Our ref: Huntlee New Town - Stage 2 (SSD-70748466)

11 October 2024

Subject: Response to Submissions

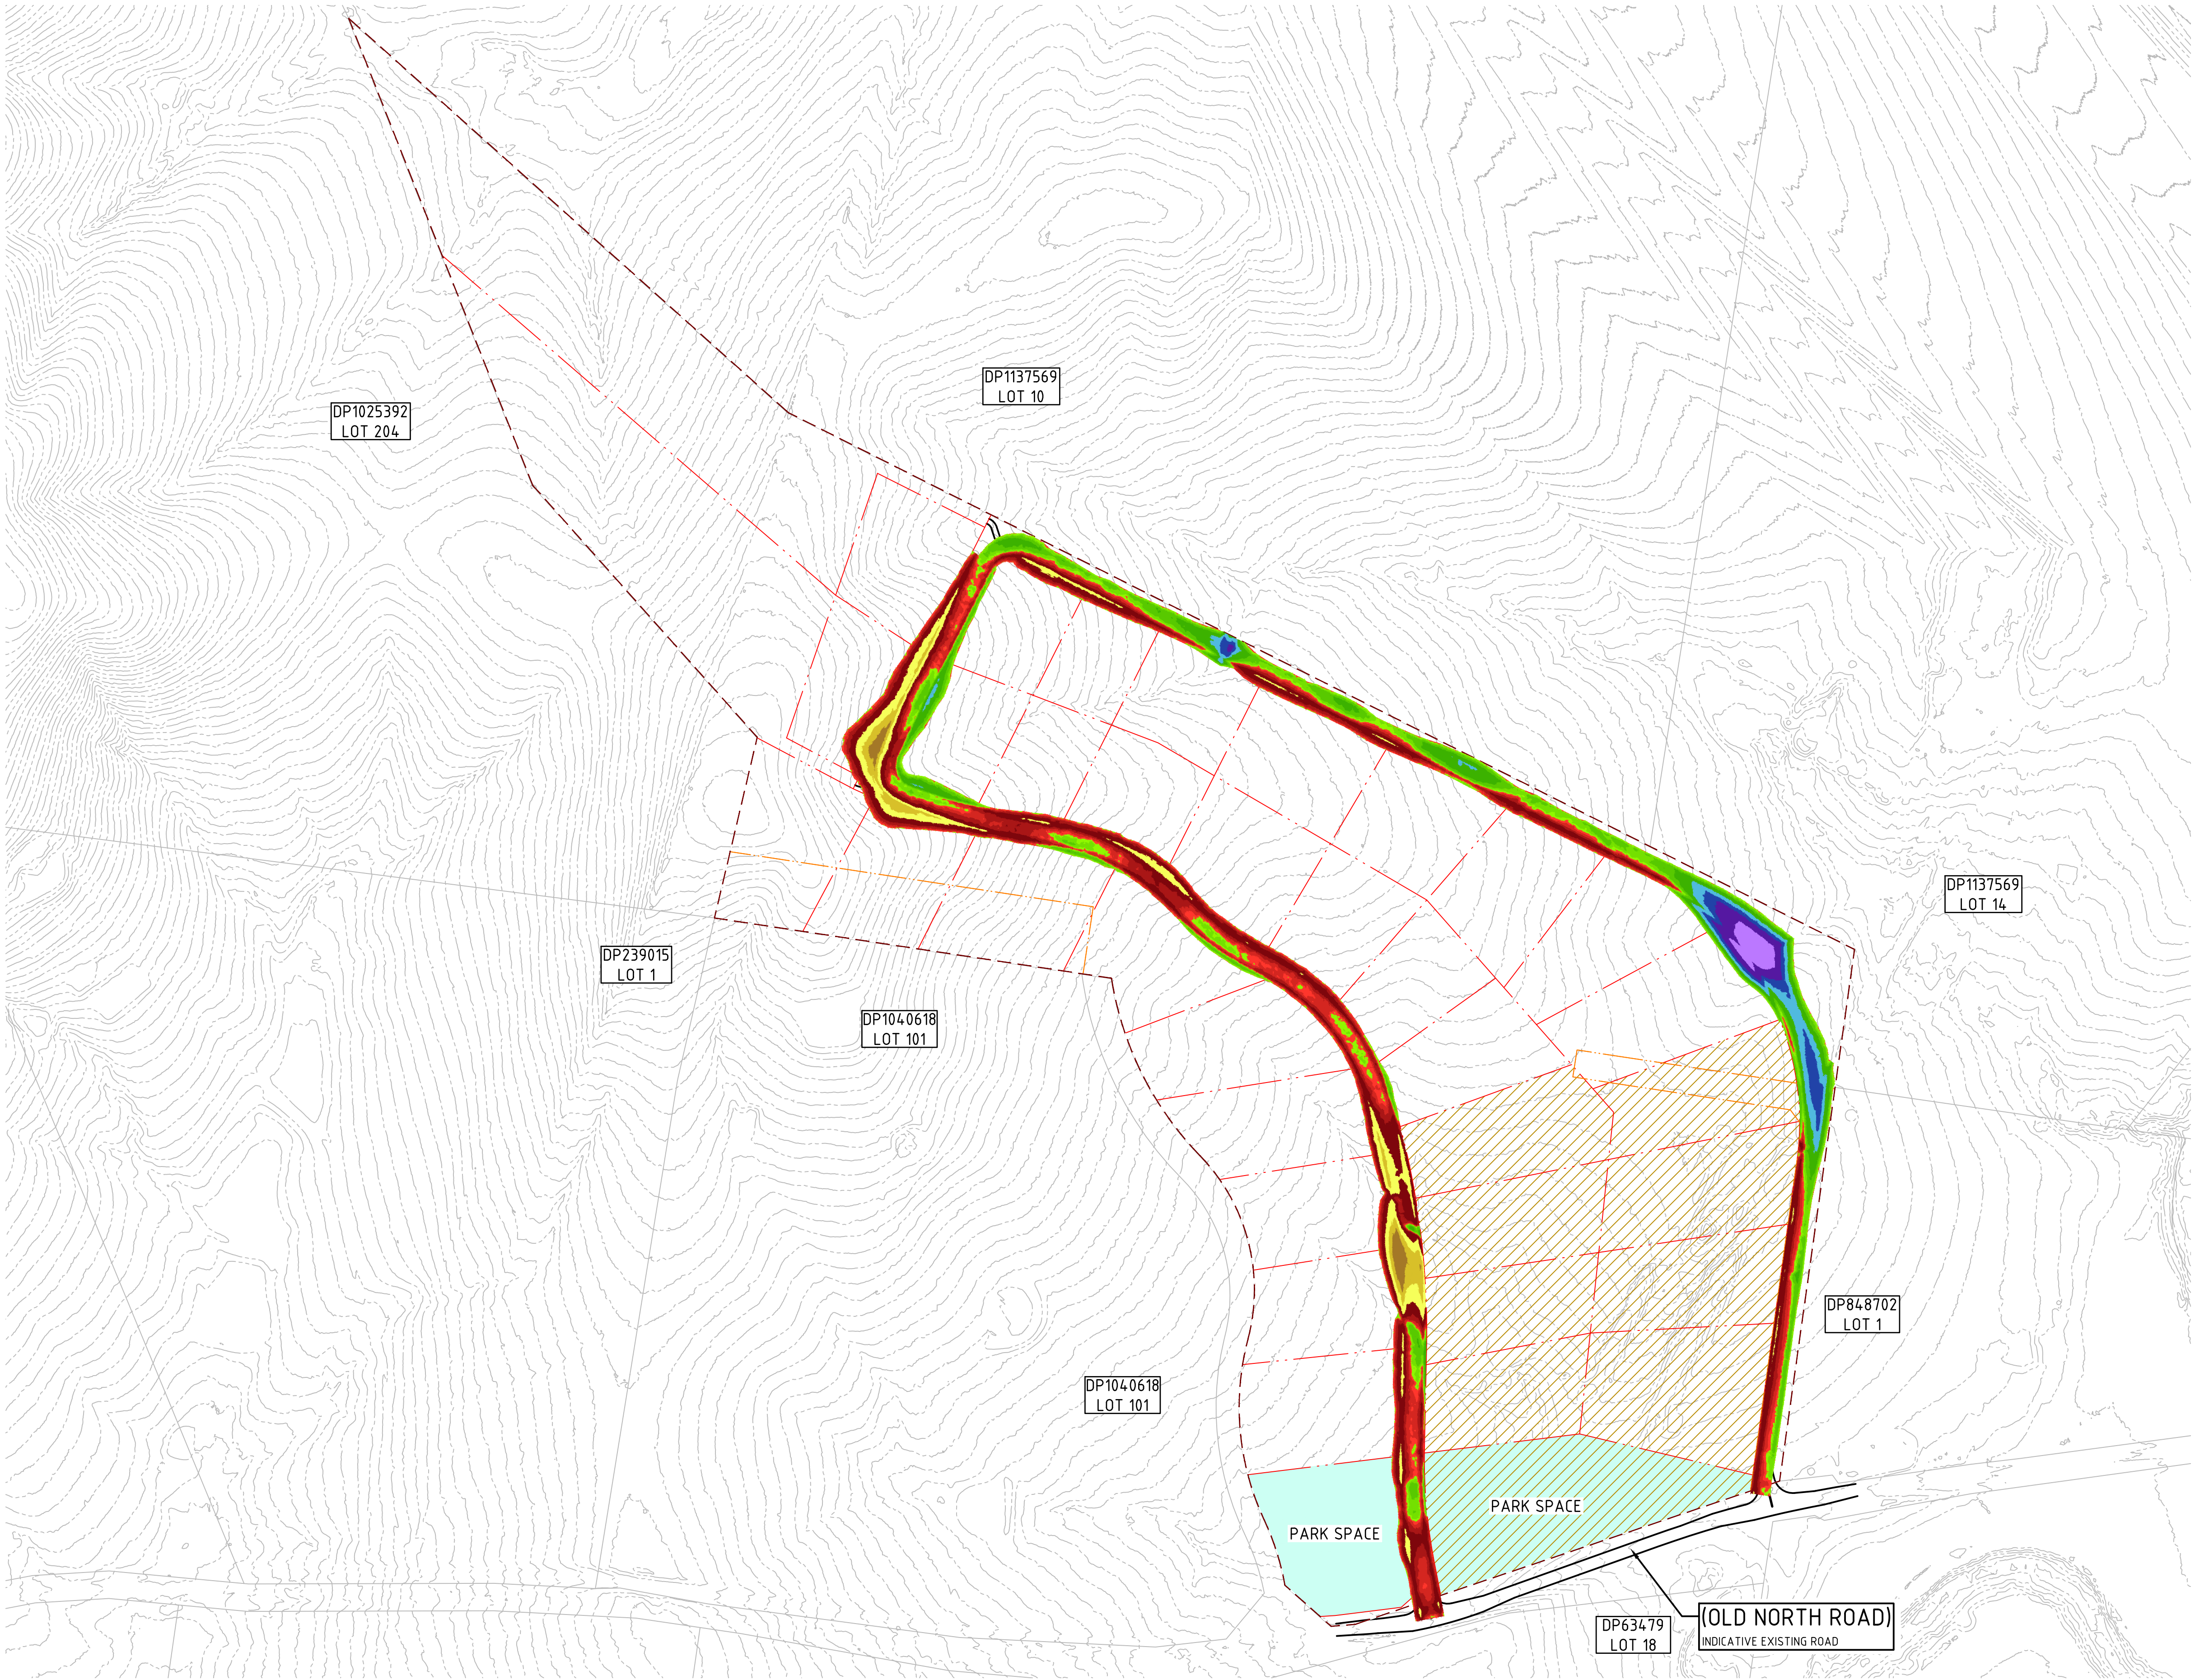
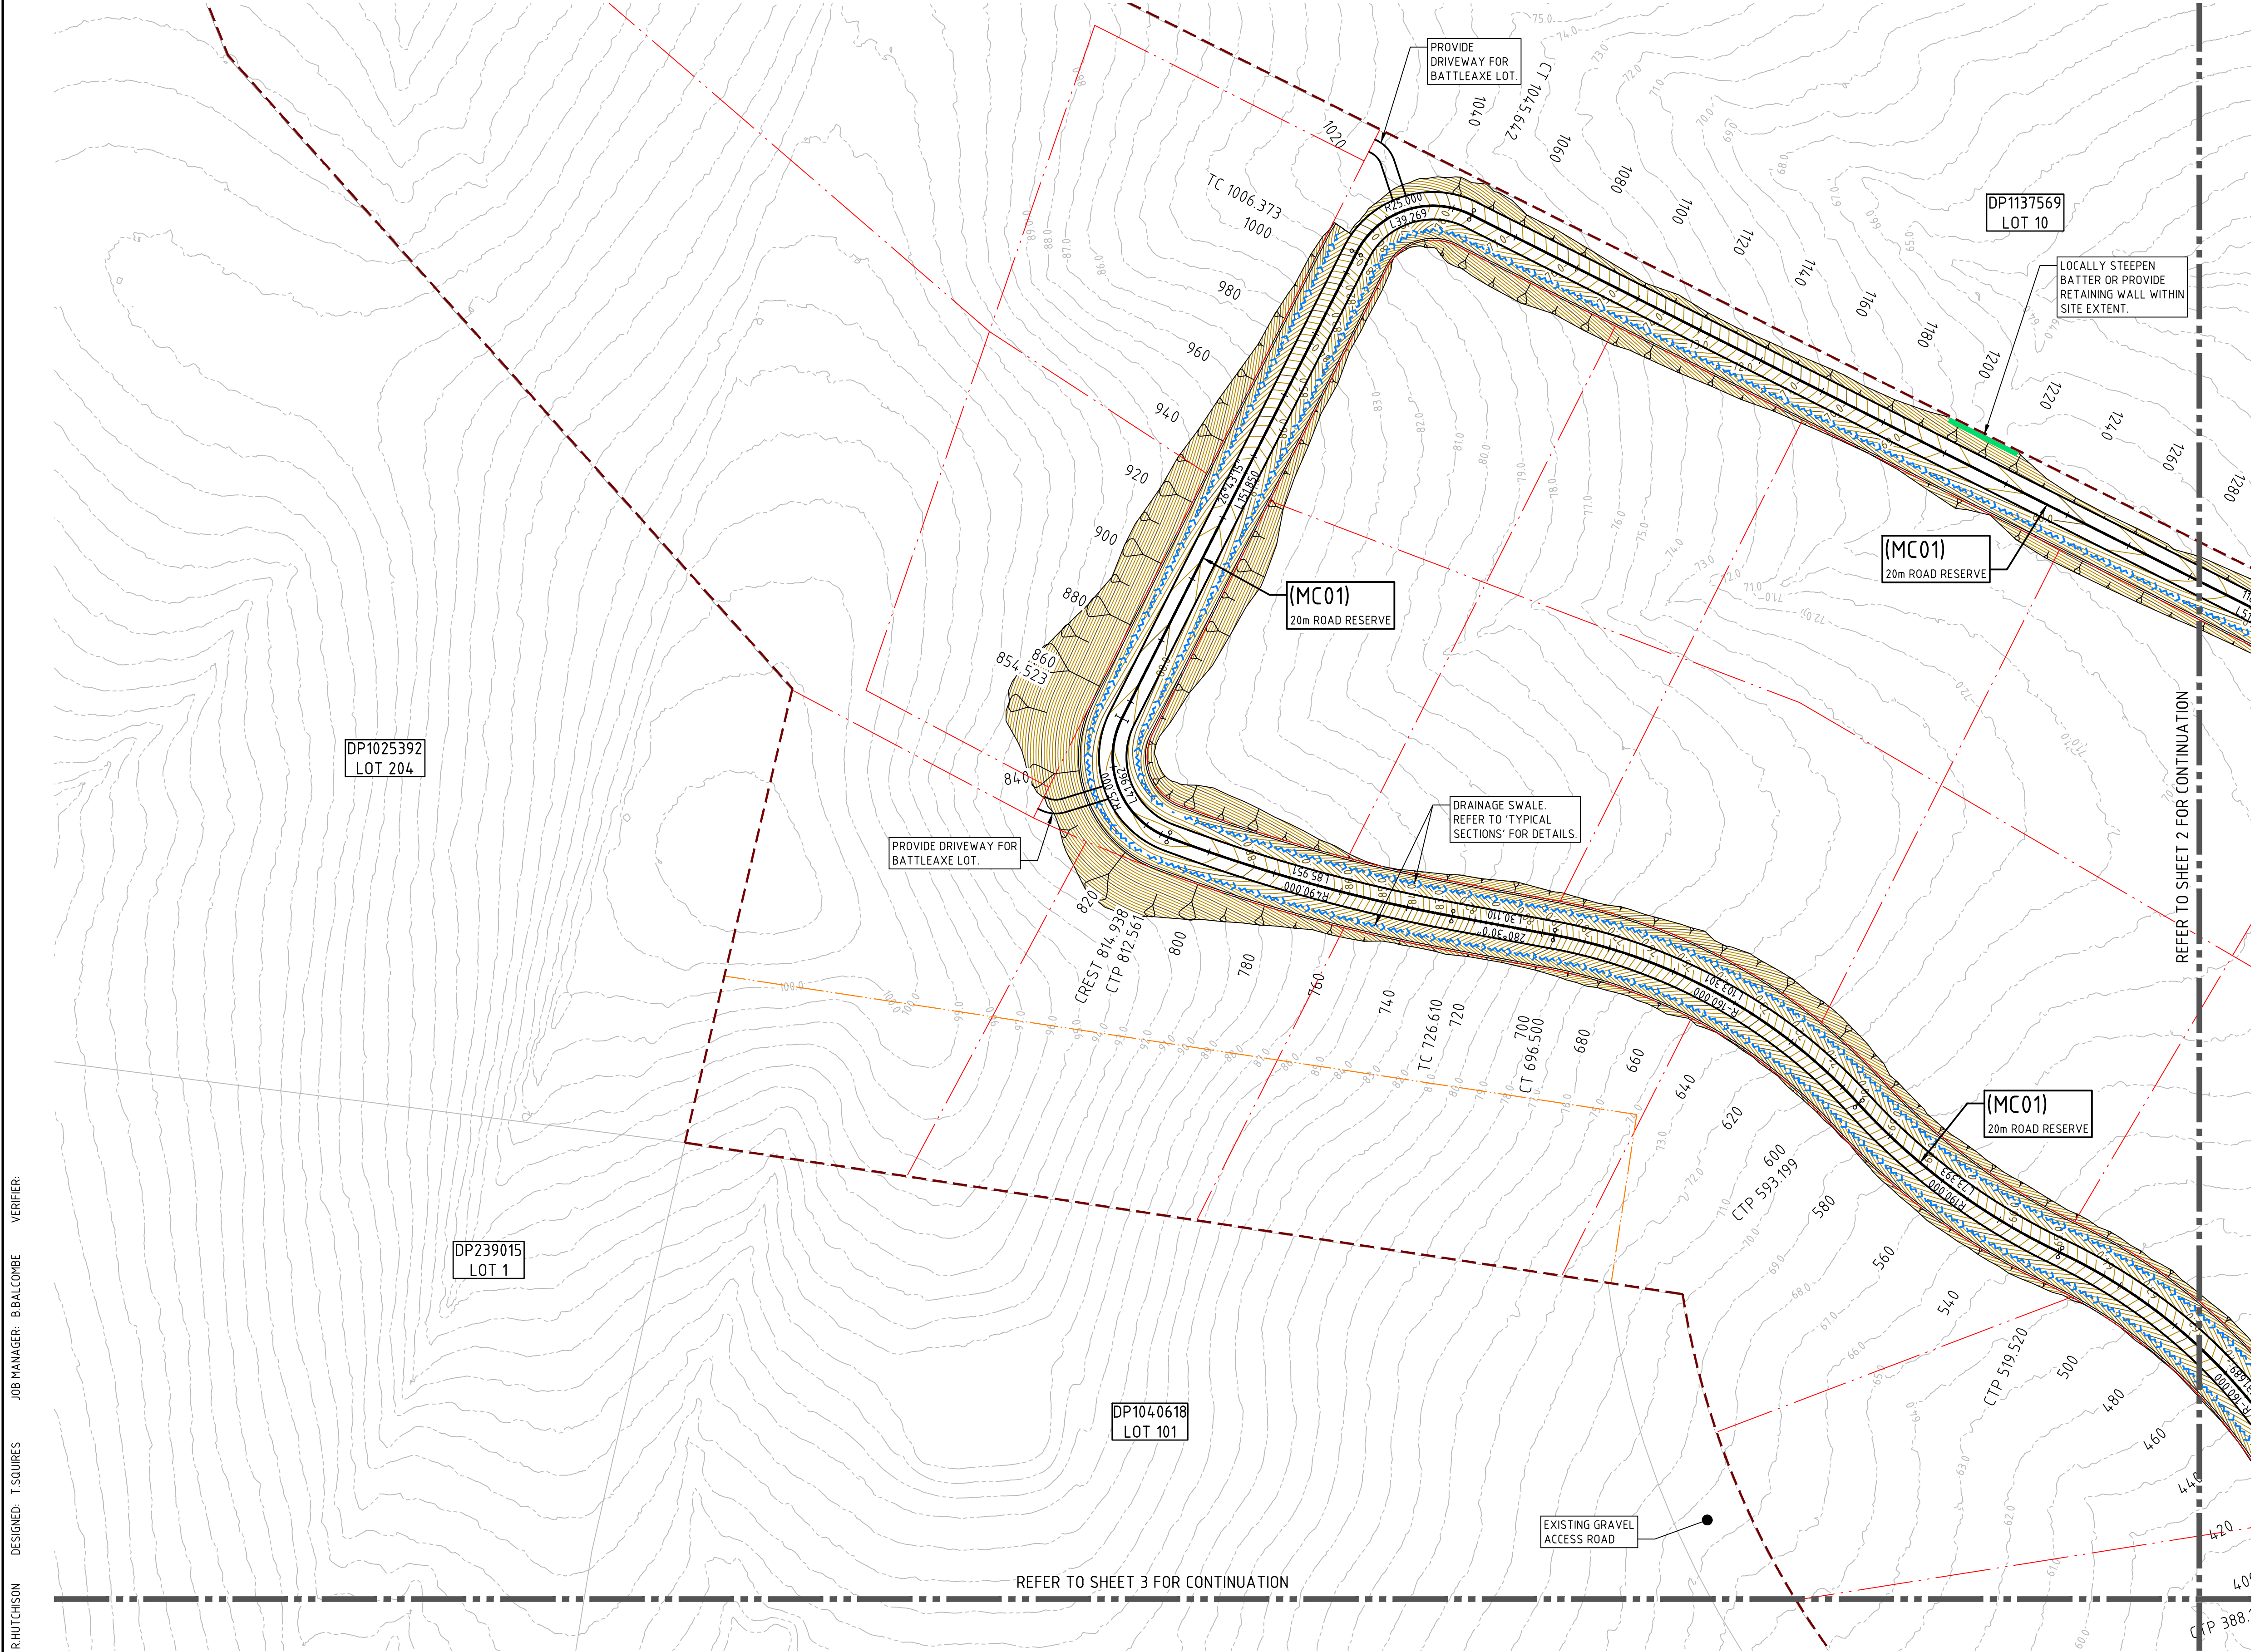
There are inconsistencies in the lot numbers and layout between the civil design plans and the subdivision plans.

- revised Civil Design Plans that have a consistent lot layout with the subdivision plans
